LAND USE AND ACCESS

LSC Responses to TIS Redline Comments

Figure 10
2044 Total Conditions
 Commons at Falcon Field (LSC# S234220)

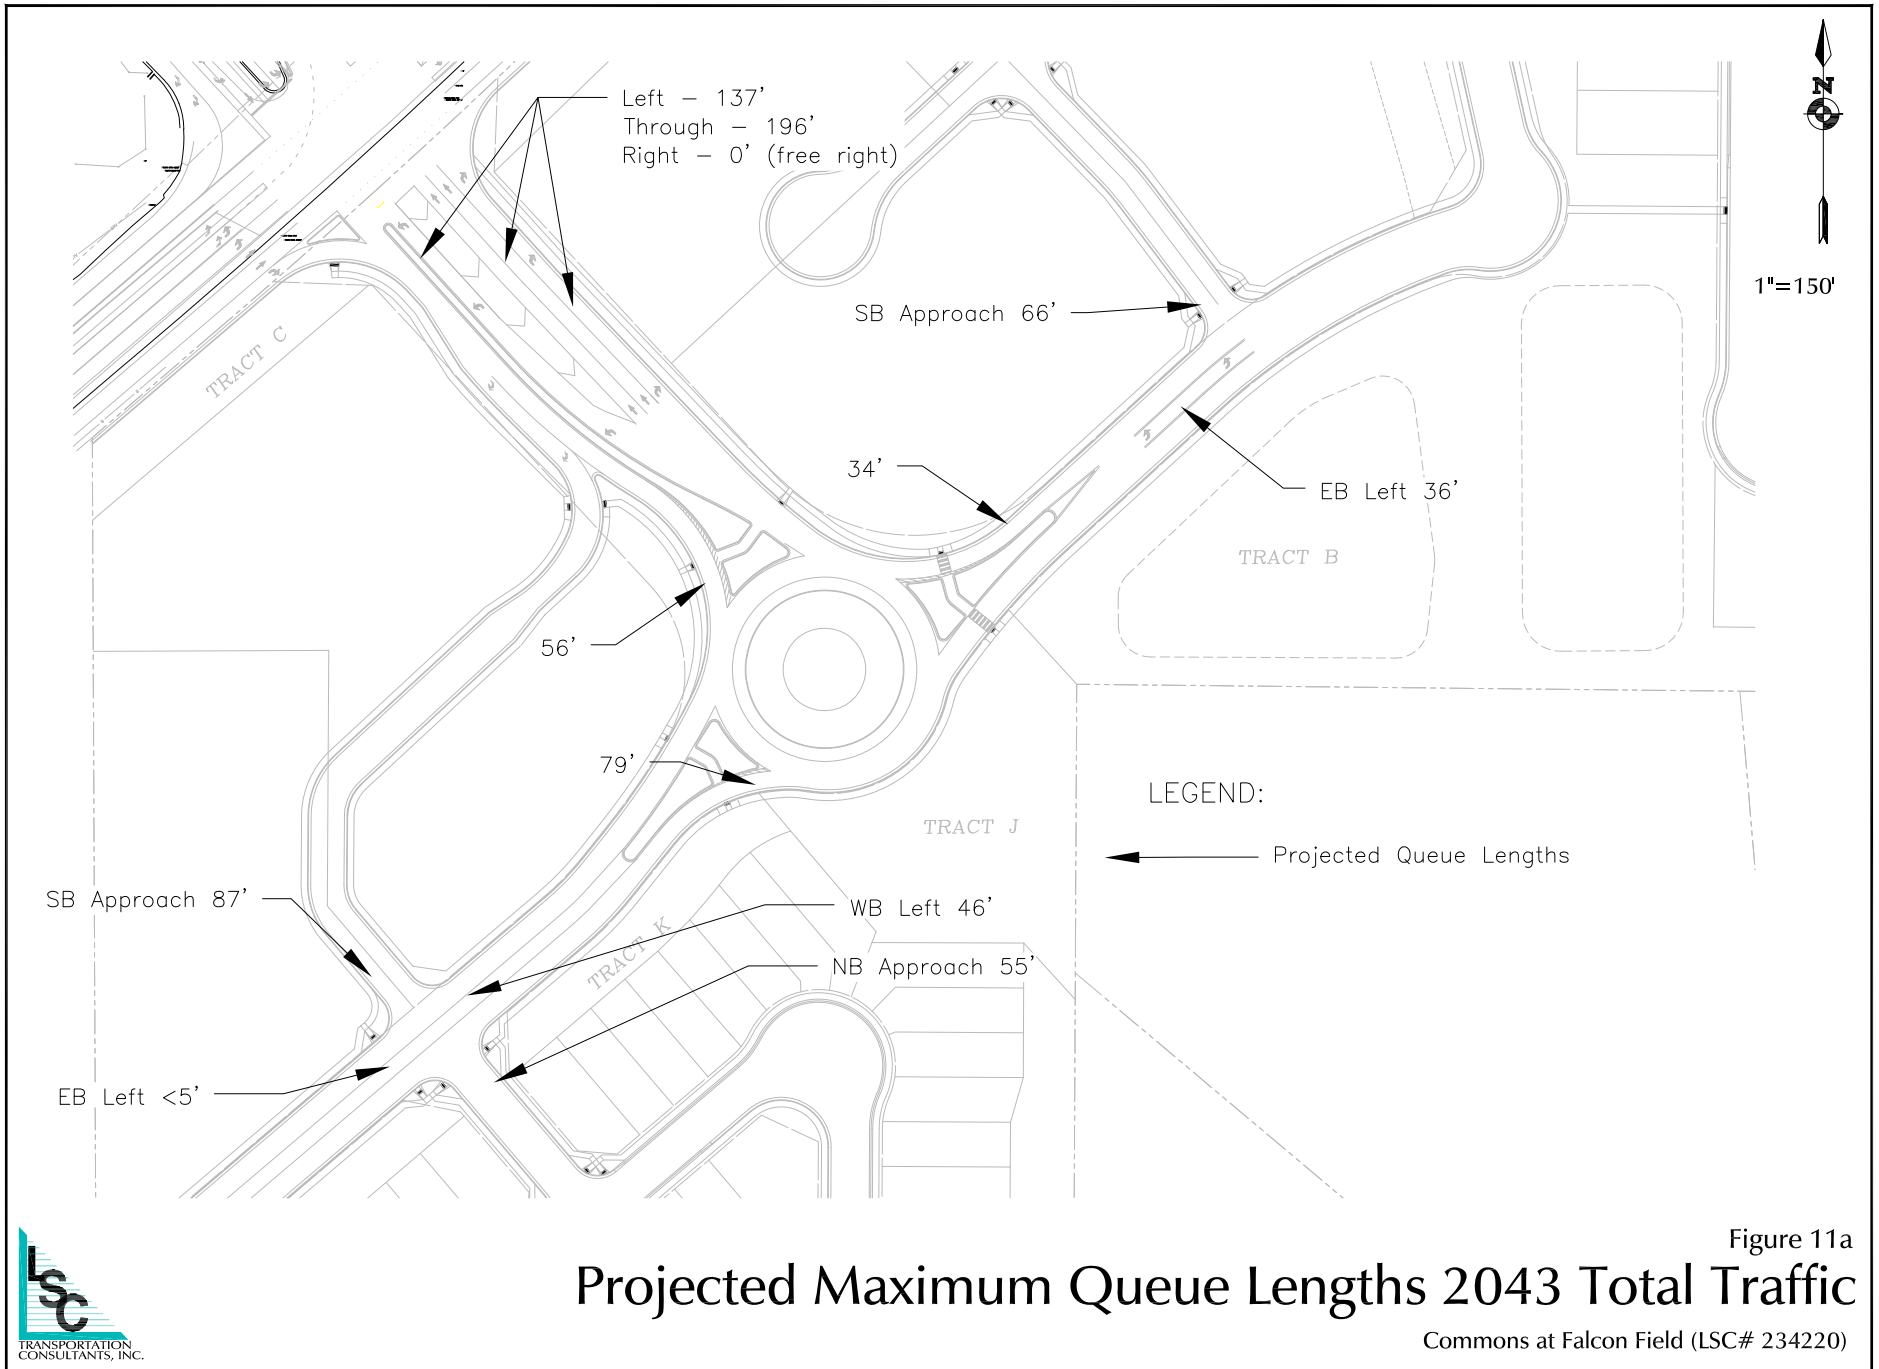
figure 10 long term total indicates D. Revise accordingly.

figure 10 long term total indicates D. Revise accordingly.

Author: kdferrin Subject: Sticky Note Date: 3/6/2024 4:37:01 PM
LSC Response: Revised as requested.
